WELWYN HATFIELD BOROUGH COUNCIL – DEVELOPMENT MANAGEMENT
DELEGATED REPORT

APPLICATION No: N6/2013/2219/FP

SITE ADDRESS: 7 Densley Close, Welwyn Garden City

DESCRIPTION OF DEVELOPMENT: Erection of single storey front, side and rear extension and alterations to roof

FIRST FLOOR PLAN

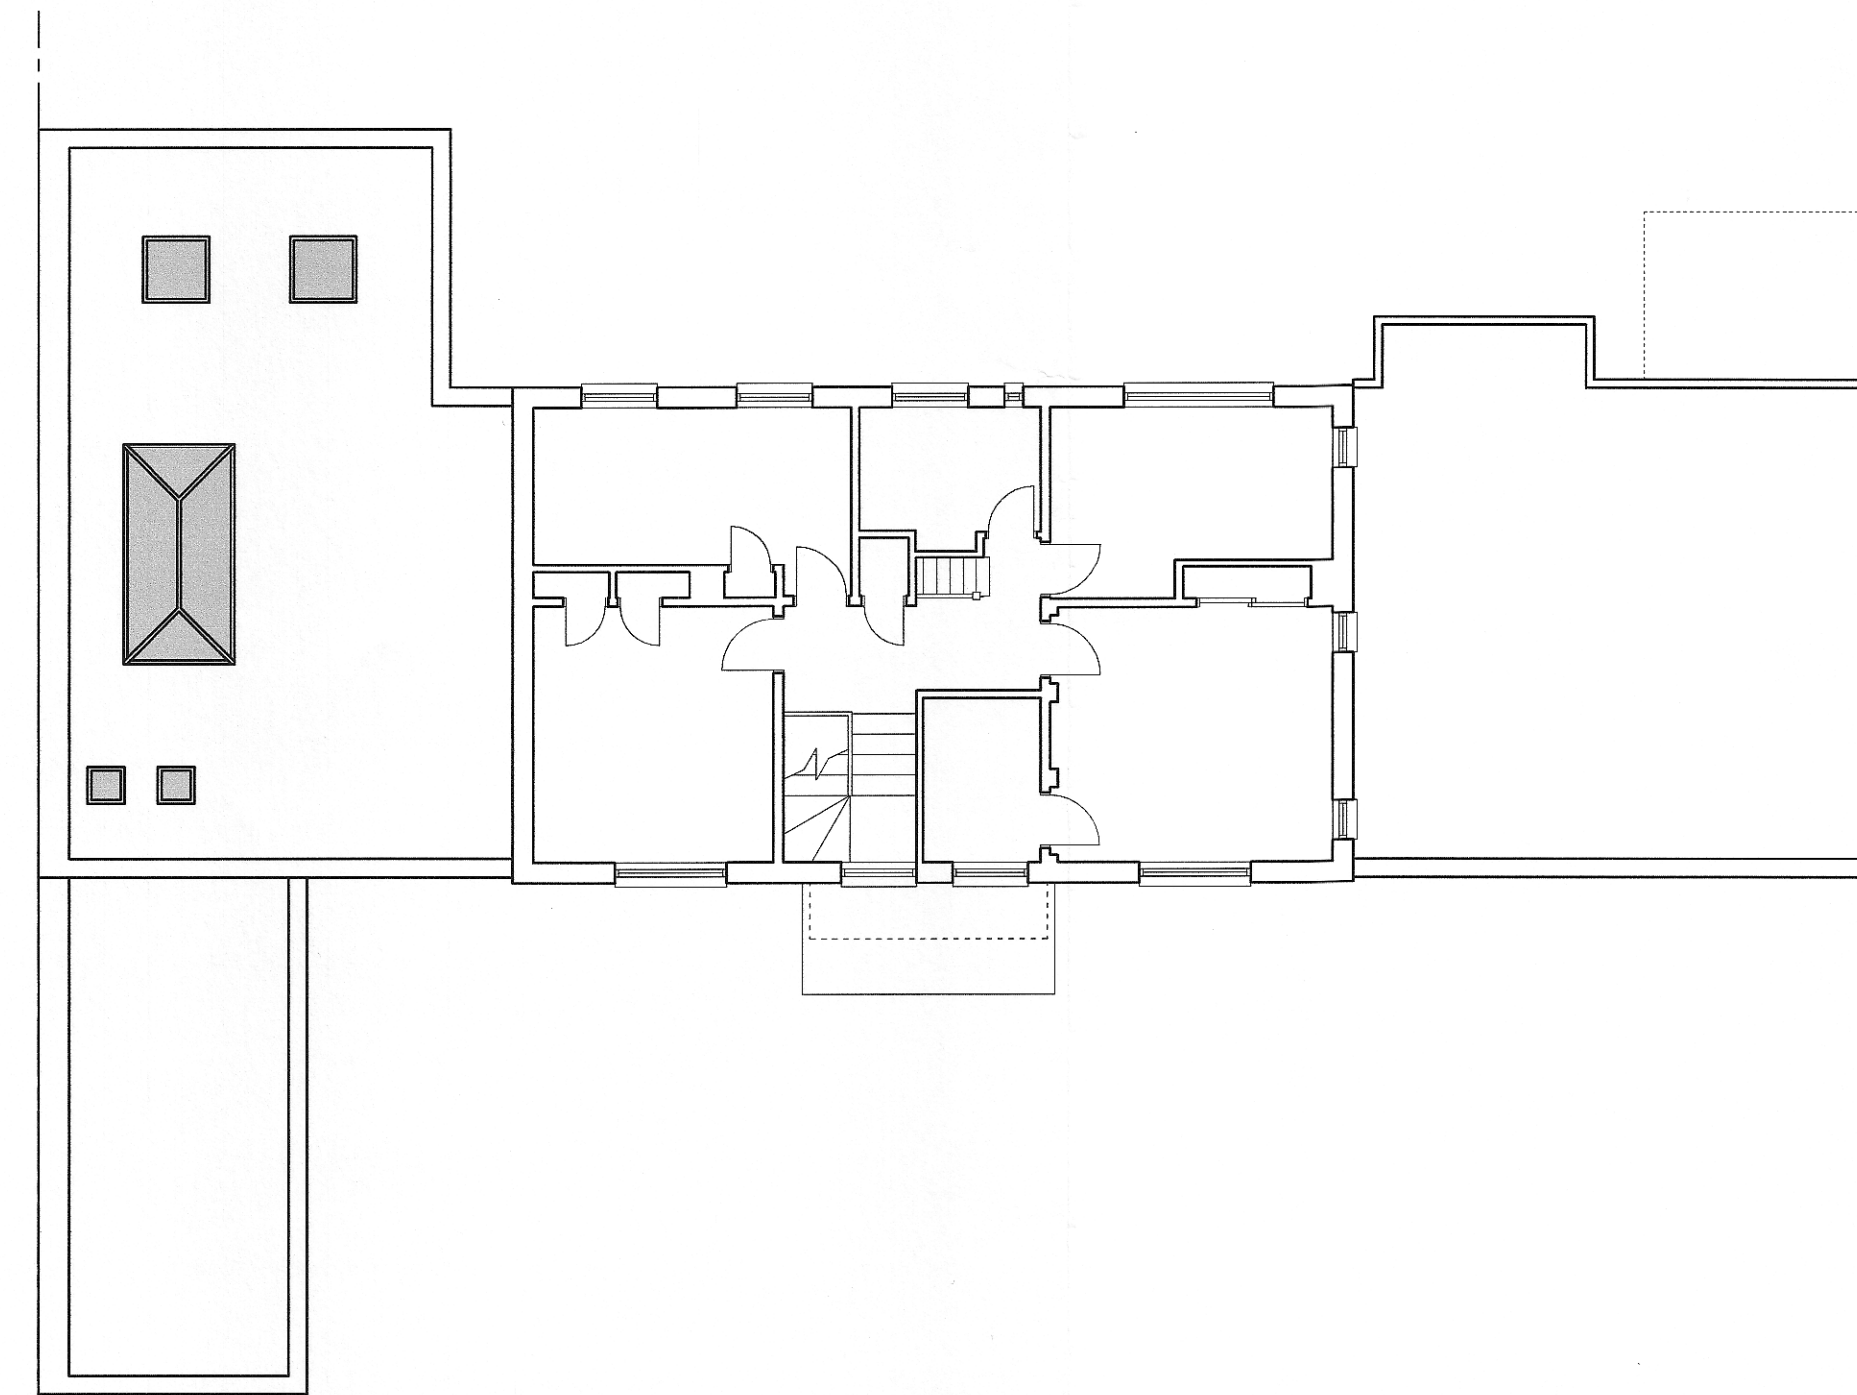
The proposal seeks to replace the existing single storey side extension along the northern elevation with a single storey side extension increasing the height of the extension to a maximum 3.25m and increasing the depth at the rear by a further 1m. Furthermore, the existing single storey extension attached to the southern elevation will increase in height by a further 0.2m. The proposal differs from that previously refused under planning application, ref: N6/2013/1278/FP, by virtue of the northern elevation extension being reduced in height by 0.35m and the southern elevation extension being reduced in height by approximately 0.35m. The proposal was refused by virtue of the height of the parapet wall being near to the height of the first floor window sills which would appear stark and over dominant within the streetscene.

It is considered that the proposal has been sufficiently reduced in height to reduce the overall bulk and would more in keeping with the height of the parapet walls which exist within the streetscene. Furthermore, the proposal would incorporate coping stone as the parapet finish. The rooflights proposed on the northern side extension will not be visible within the streetscene and has been confirmed through an email from the agent, dated 10 December 2013. It would also be appropriate for condition the application for samples of materials to be submitted prior to commencement of development to ensure the materials appropriately match the existing dwellinghouse.

The properties most impacted by the proposal are neighbouring properties, No. 5 Densley Close to the north and No.19 Scholars Mews to the south. The existing garage is attached to the neighbouring single storey side extension at No.5 Densley Close. The existing garage already extends further beyond the rear of No.5 by approximately 1m with the proposed replacement side extension resulting in approximately 2m extension beyond the rear of No.5. Windows exist on the rear of No.5 in close proximity to the proposed extension however a 2m extension is not considered to result in an unduly dominant feature when viewed from these windows. Furthermore, the proposal is not considered to detrimentally impact upon loss of sunlight/daylight skylight when compared to the existing extension taking into consideration the extension will only extend a further 1m in depth and the orientation of No.5 to the north east of the application dwelling where a limited amount of light reaches these windows during large parts of the day.

The proposed height increase of 0.2m to the existing single storey side extension extending beyond the southern elevation is considered sufficient distance from No.19 Scholars Mews (approximately 10m) not to detrimentally impact upon loss of sunlight/daylight. The existing side windows are being retained with the floor level increase internally of approximately 15cm. However, the existing window openings and siting are not being altered and therefore the proposal is not considered to result in any further overlooking/loss of privacy to neighbouring properties when compared with the existing situation. The proposal is therefore considered in accordance with policy D1 of the Welwyn Hatfield District Plan, 2005.

2. C.13.1 Development in accordance with approved plans/details: 3081-OS1 & 3018-OS2 Rev A received and dated 24 October 2013 & 3018-P01 Rev C received and dated 11 December 2013
